Waterloo Metro Quarter OSD Northern Precinct

Detailed State Significant Development
Application
SSD-79307758

Supplementary Design Report
Response to Submissions

WMQ-BD1-WBG-AR-RPT-002

OVERALL ARRANGEMENT - GROUND FLOOR

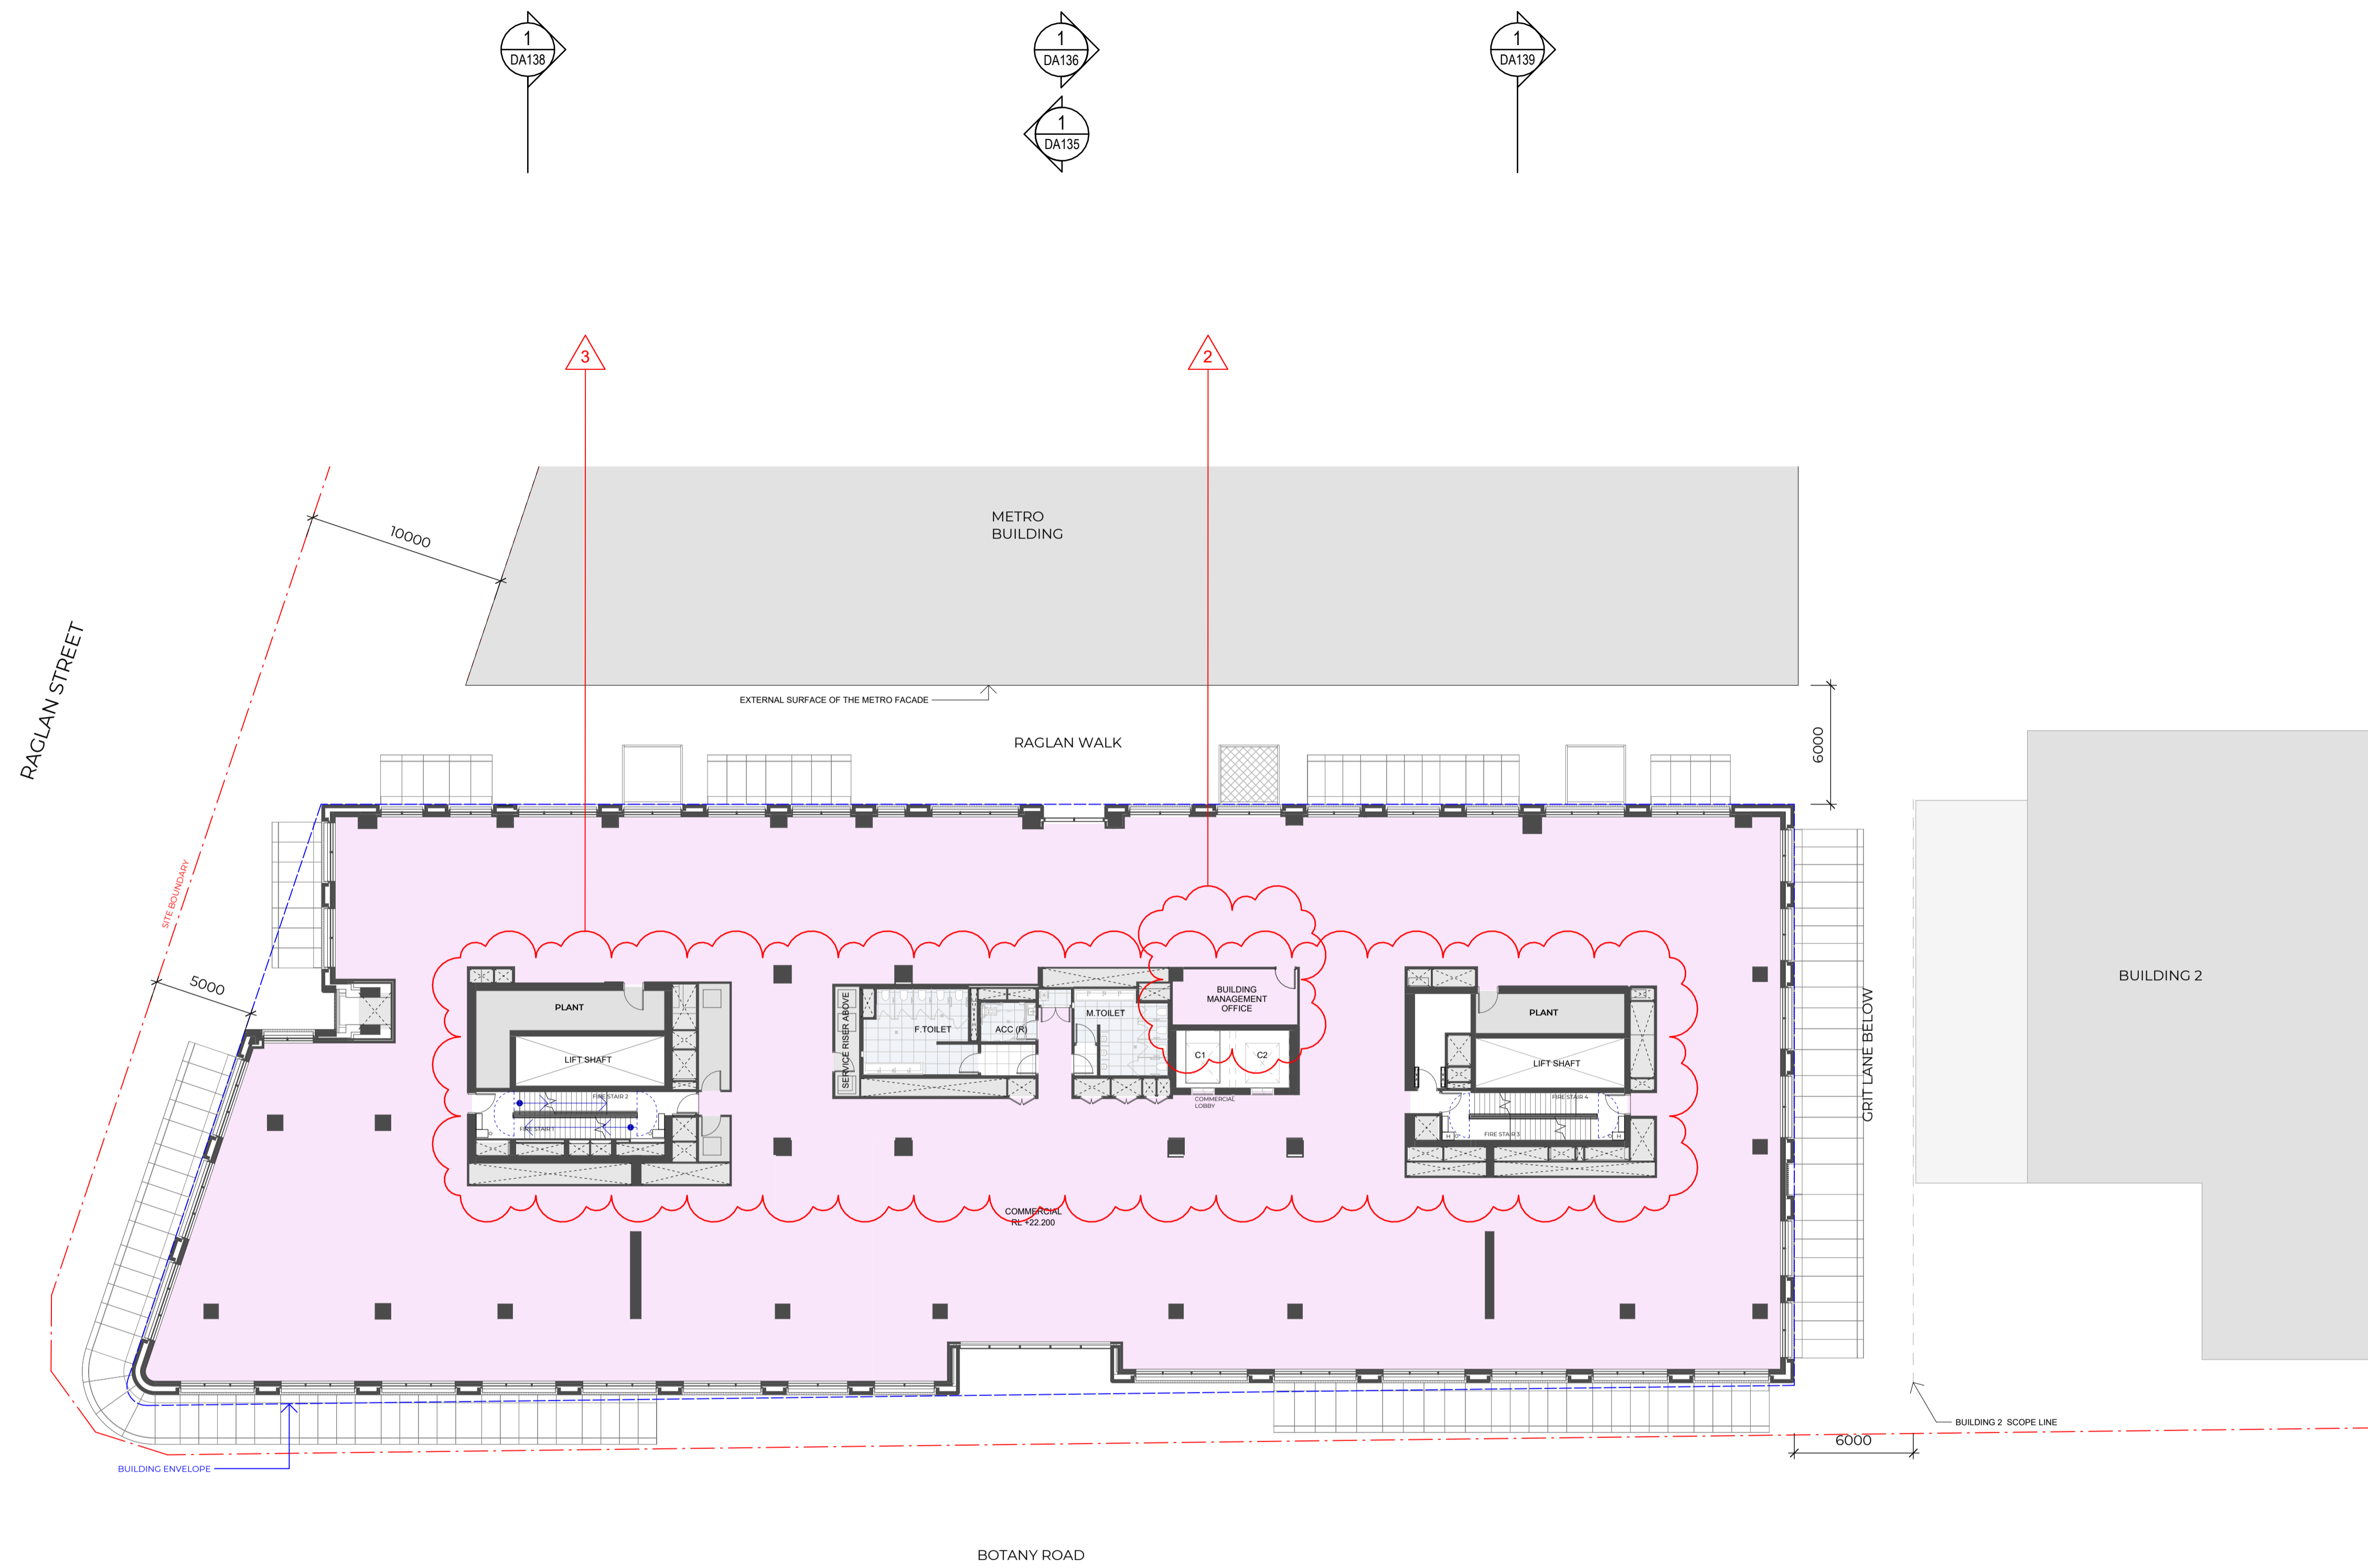
o review the design of ground floor /retail layouts of the Northern and Central Precinct to achieve equitable access to shared amenities / back of house areas ; and address SDRP advice on Site Strategy and Built Form Point 8: Ensure that the serviceability of the retail offerings is considered during design development. For example, access to shared amenities , ventilation requirements and kitchen exhausts.

b) Provide a revised Clause 4.6 Statement addressing the objective of Sydney LEP section 6.45(1)(a) in respect to the variation of the minimum non-residential floorspace standard.

Ground level retail tenancies are supported by a centrally located shared loading dock accessed from Botany Road. Most tenancies connect directly to the loading area via a back of house corridors. Three smaller tenancies on Raglan Walk will access the loading area via the laneway; given their scale, delivery volumes are expected to be low and will be managed outside peak public hours.

Access to shared amenities is via Grit Lane, where food and beverage tenancies are located in close proximity, providing convenient access for the northern precinct. (The central precinct has its own dedicated retail amenities)

Six of the seven retail units are planned as food and beverage (F&B) tenancies. Each tenancy is designed to accommodate a kitchen exhaust system with a capacity of 2,250 to 3,000 L/s depending on the size, discharged at roof level.

Adequate make-up air intake louvres are integrated into the façade, incorporated within the shopfront window system to ensure proper ventilation balance.

The change to the **non-residential** GFA is a result of ongoing design development, which includes the additional plant and riser spaces now required.

This also includes reduction to the Tower 1A residential lobby at Ground level, resulting from the integration of the level changes within the circulation pathway in lieu of dedicated ramp. The displaced GFA has been reallocated to the adjacent retail unit.

Sheet title
OVERALL ARRANGEMENT - LEVEL 1

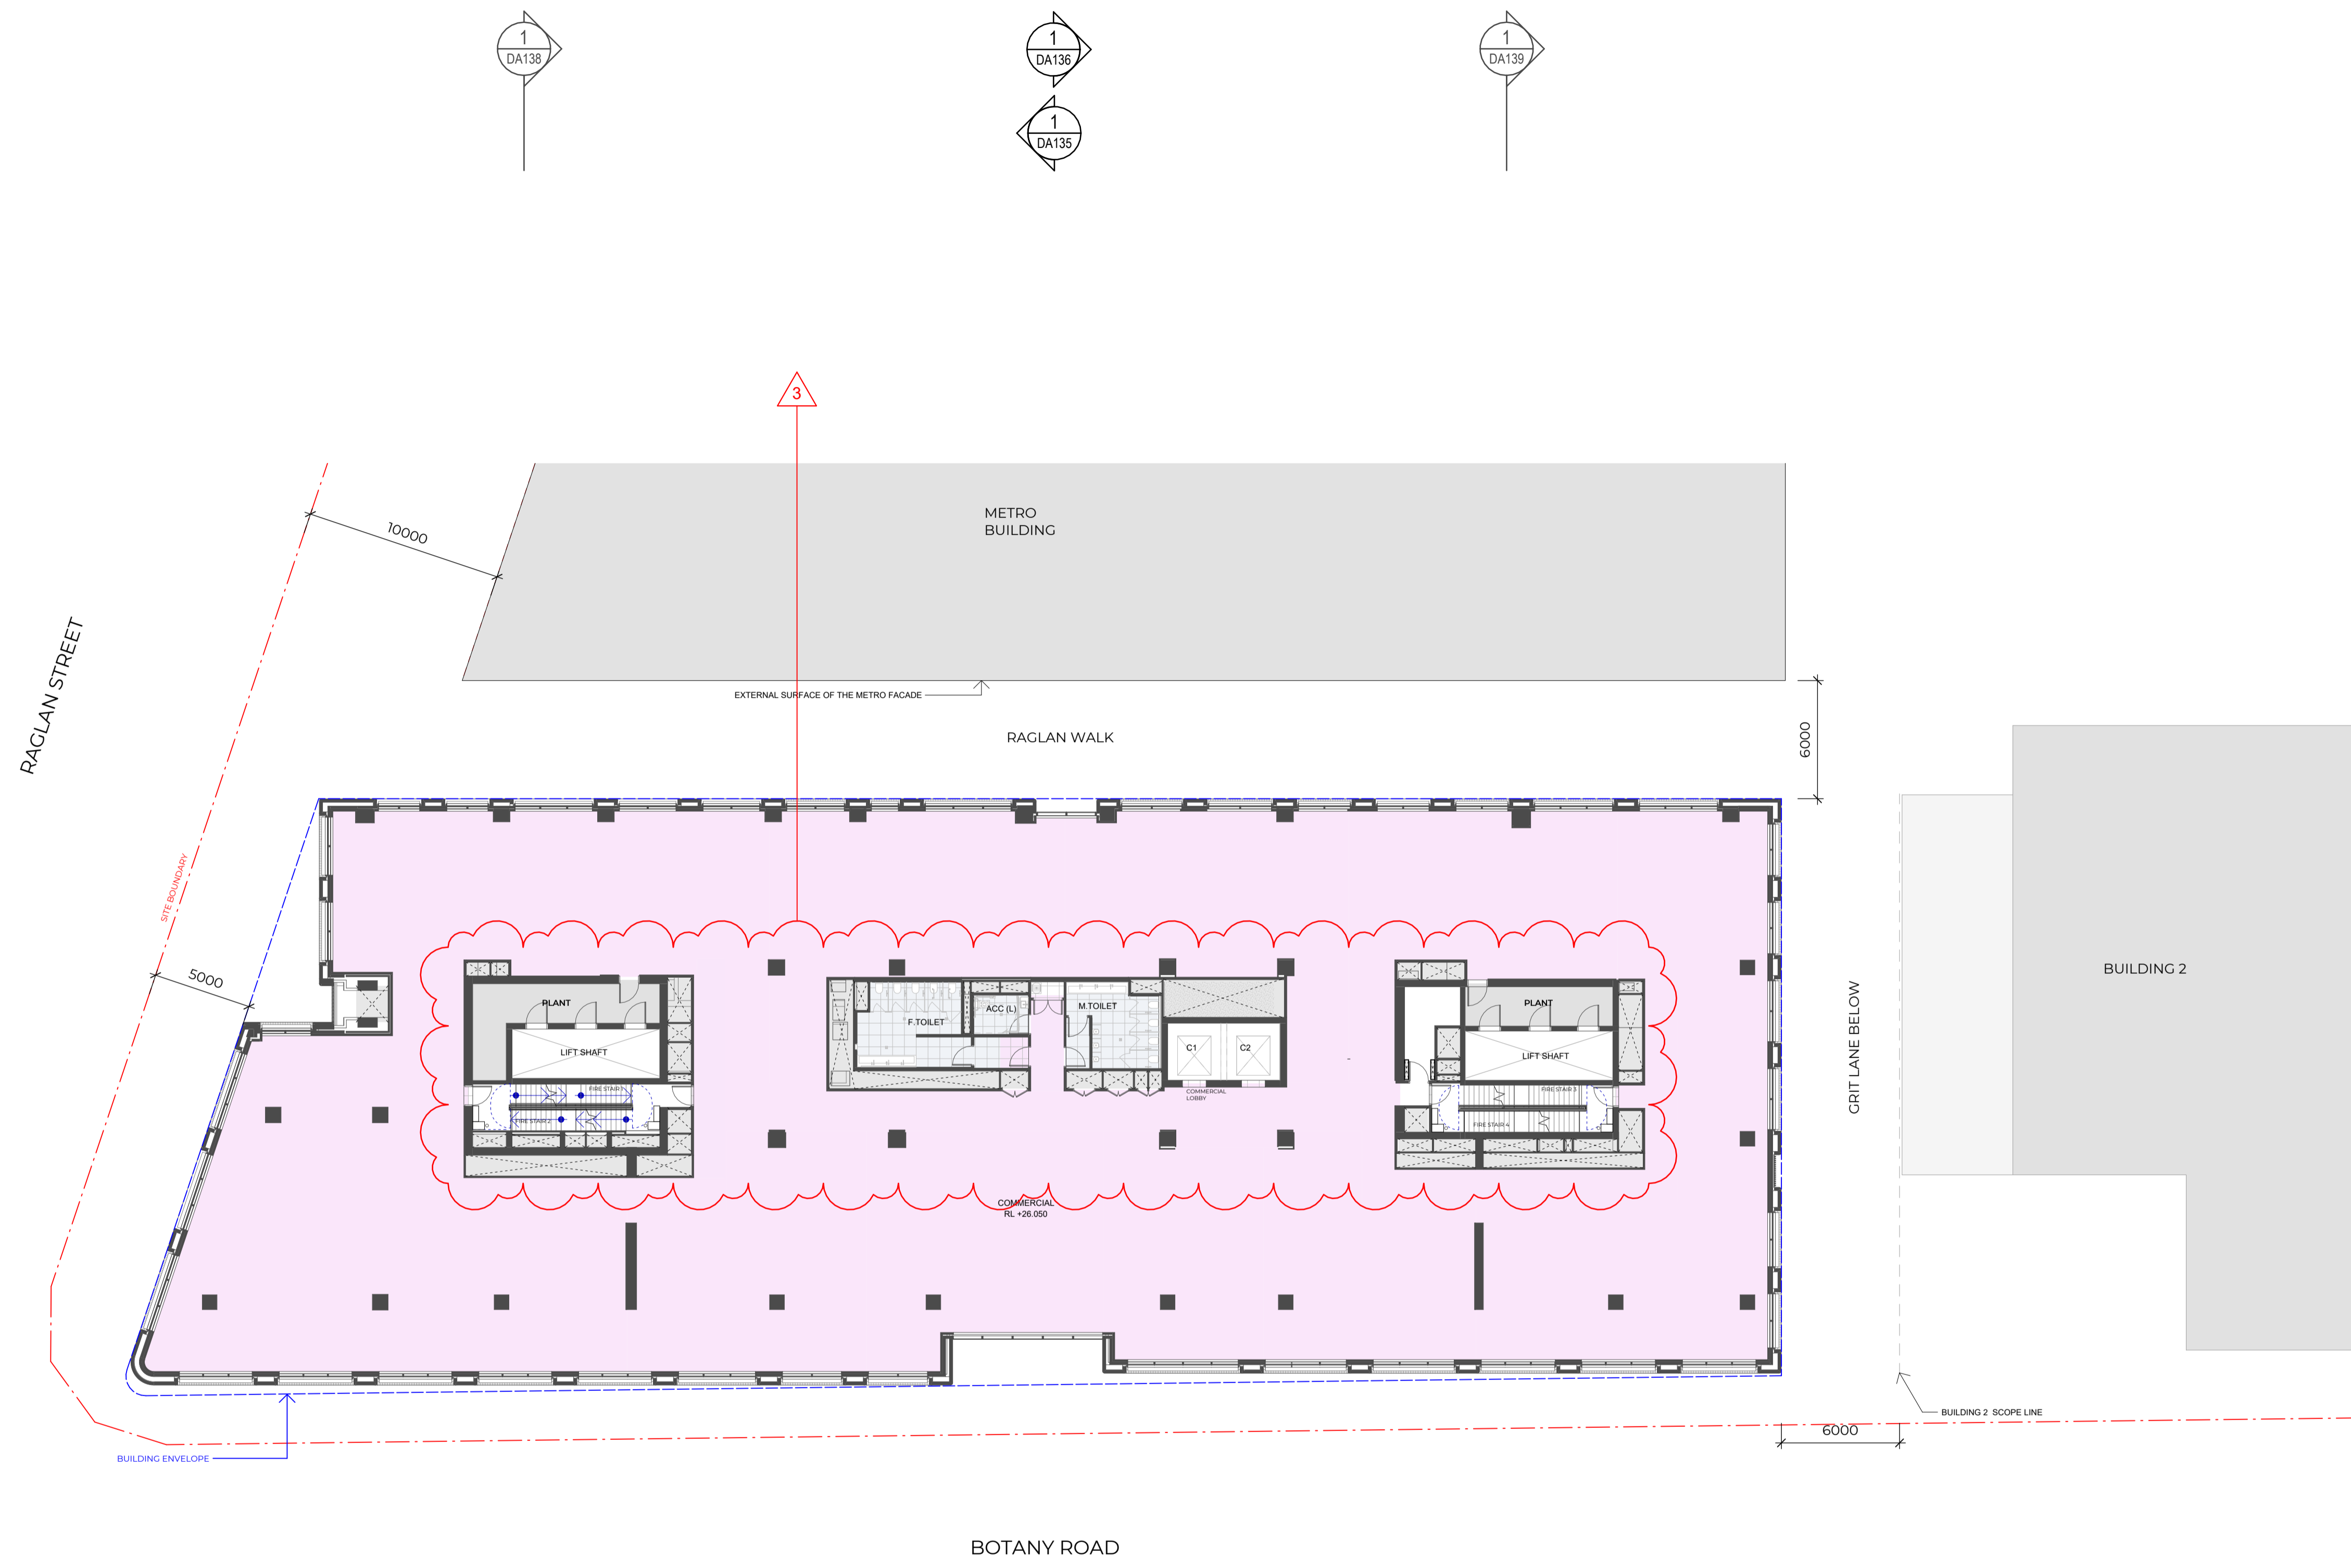
b) relocate the habitable use (building management office) from the basement

The diagrams on this page illustrate the proposed relocation of the building management office from the basement to Level 1.

Moving the office above ground level removes it from the identified flood-risk zone, ensuring all habitable areas remain protected. The relocation also improves overall amenity by providing access to natural light and a more functional working environment.
